Comments on the amended plans for planning application **2021/62/93013**, which now appears to be for the erection of a single storey side, single storey rear, rear dormer extension, and demolition of the existing garage at 74 Cleveland Road, Marsh HD1 4PW.

Proposed Ground Floor Plan 1:50 @ A1

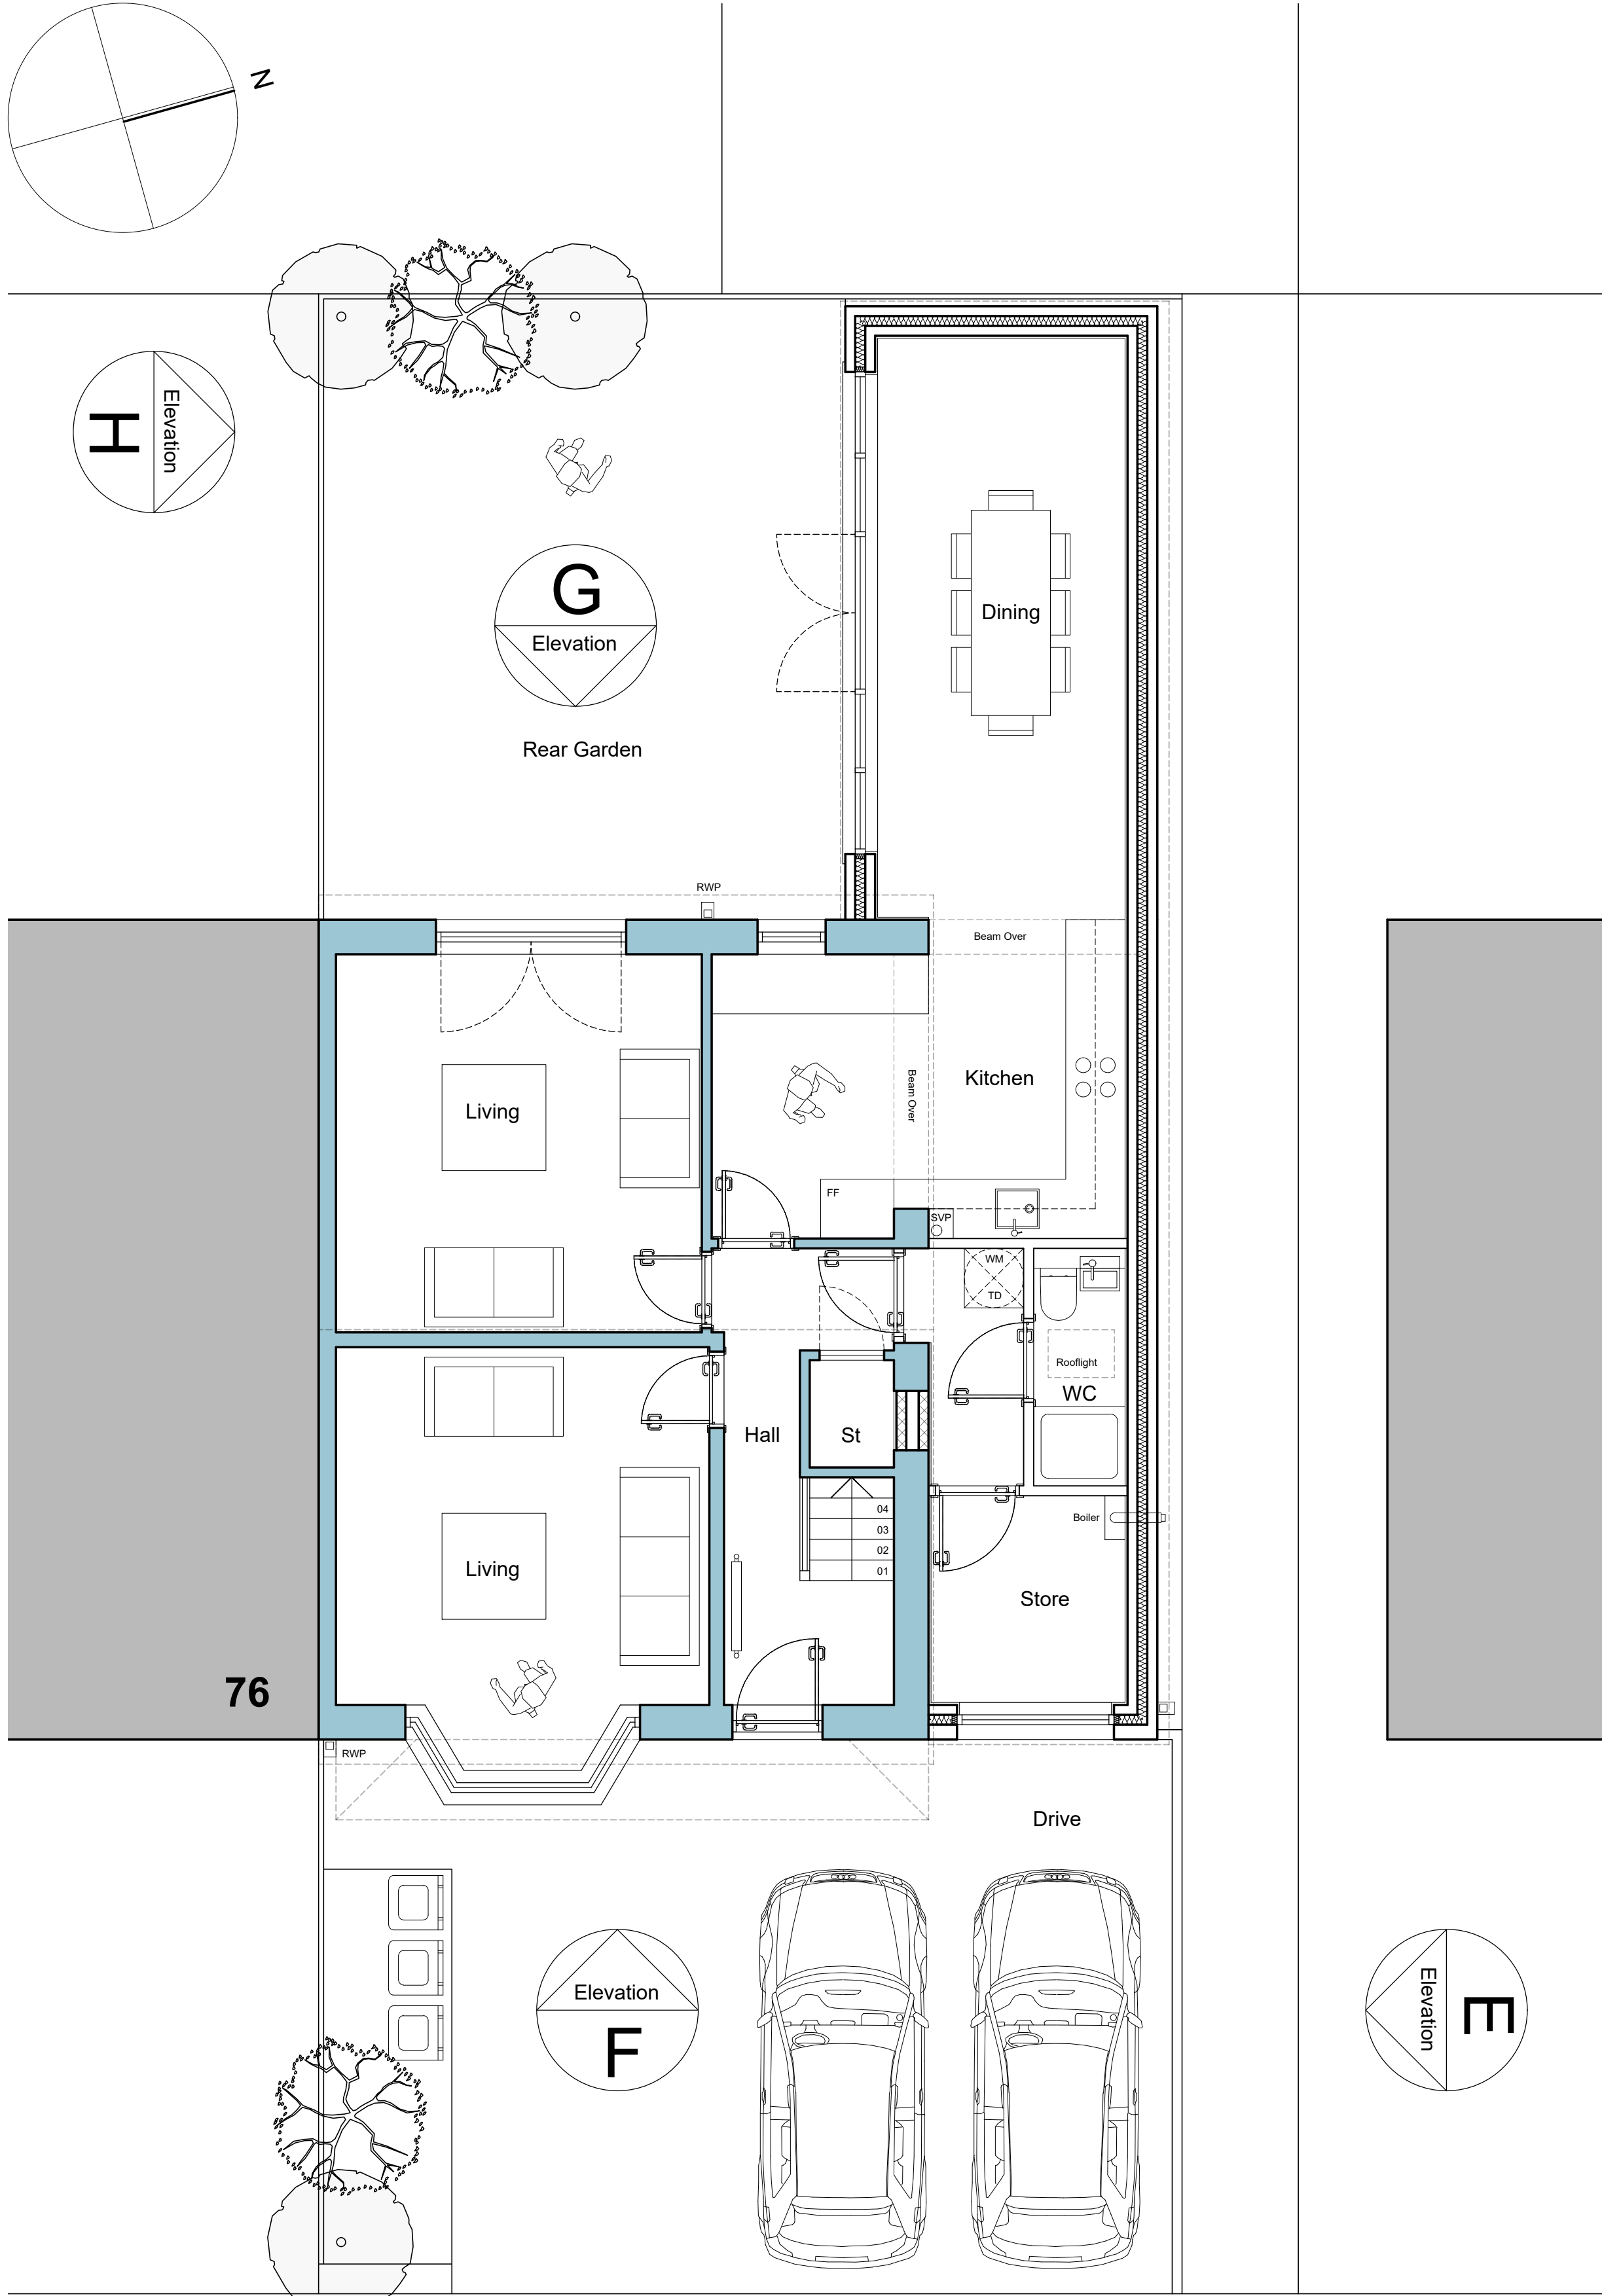
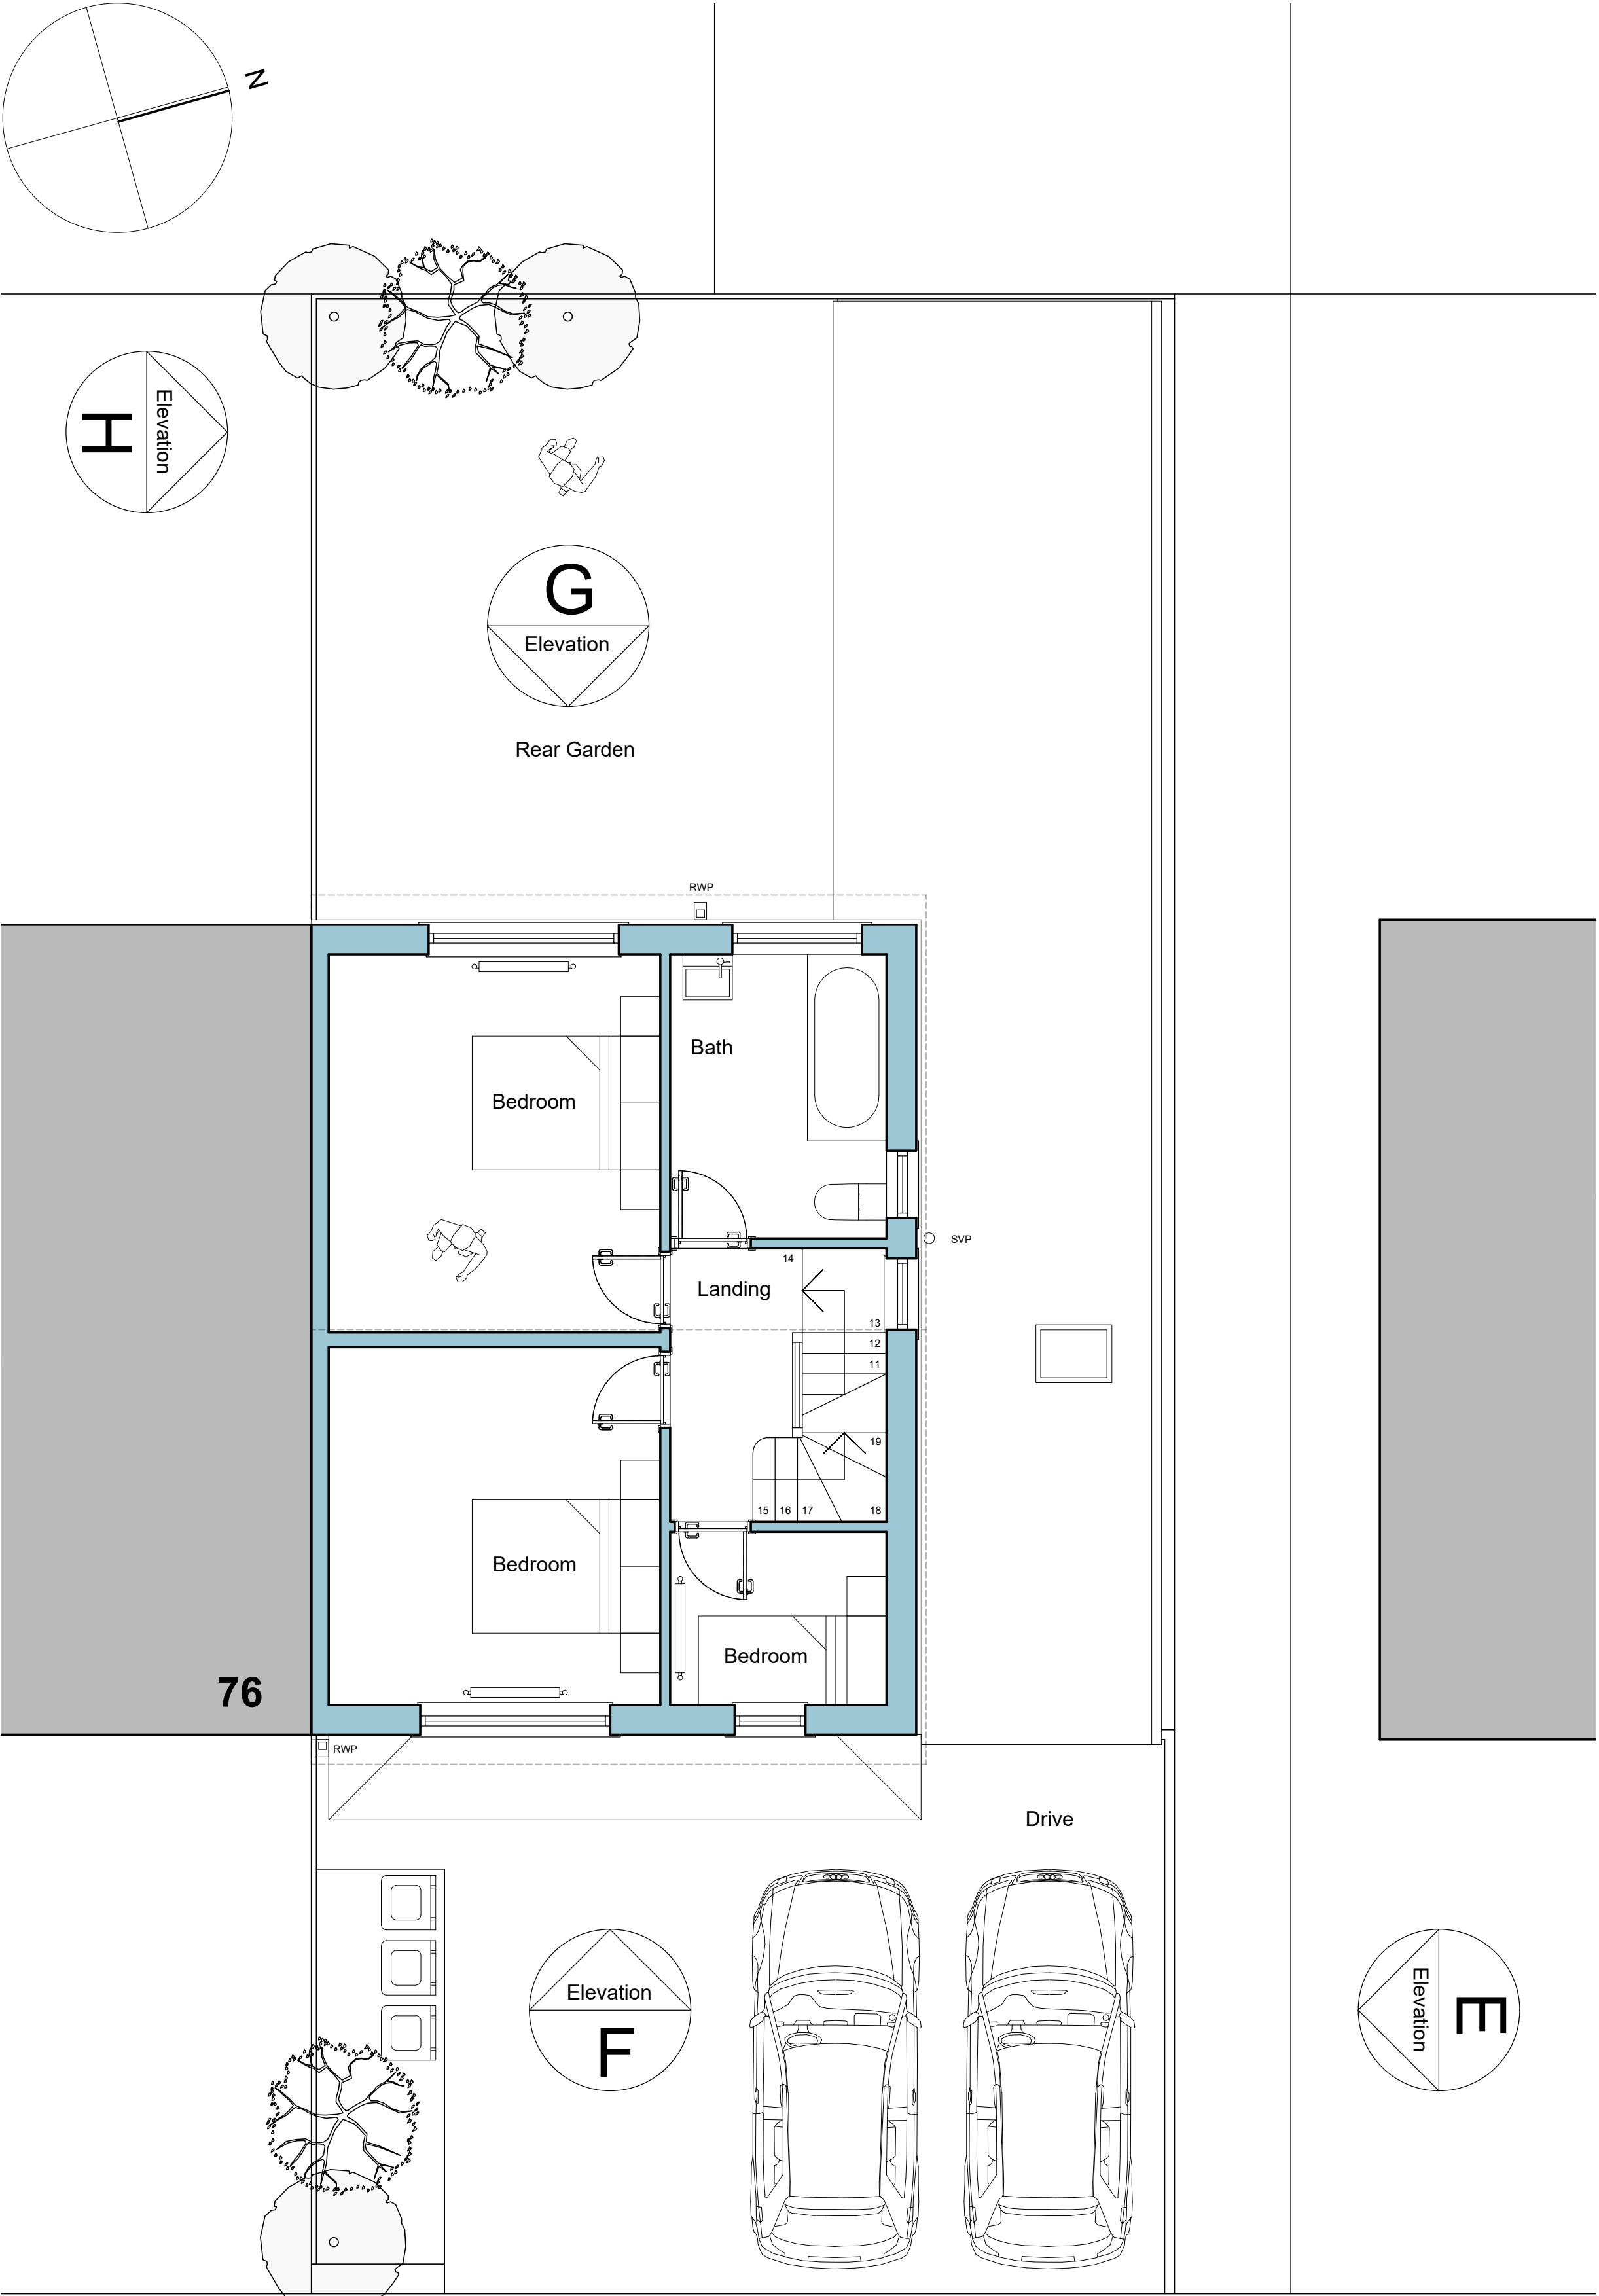
I appreciate that the scheme has been amended so that the side extension will be reduced in height but clearly the extensions of the existing property when viewed together remain very large in scale compared to the existing plot size. In particular, the proposed rear extension will extend the entire distance to the rear of the plot, which meets the boundary line of my property. Similarly, the side extension will extend the full width of the plot to the boundary line of my property where there is an access path thus creating an extremely blank and stark facade from my rear garden. Policy LP24 does not support the scope for such extensions to residential properties and the resulting impact that they can have so I remain unable to see how the proposed extension can comply with Policy LP24 and therefore should not be granted planning permission.

I also remain extremely concerned how this proposed side and rear extension is physically going to be constructed. It is shown abutting the boundary of my property to the rear and to the side and I fail to understand how the build can take place without access rights on to my land, which I can confirm have not been granted.
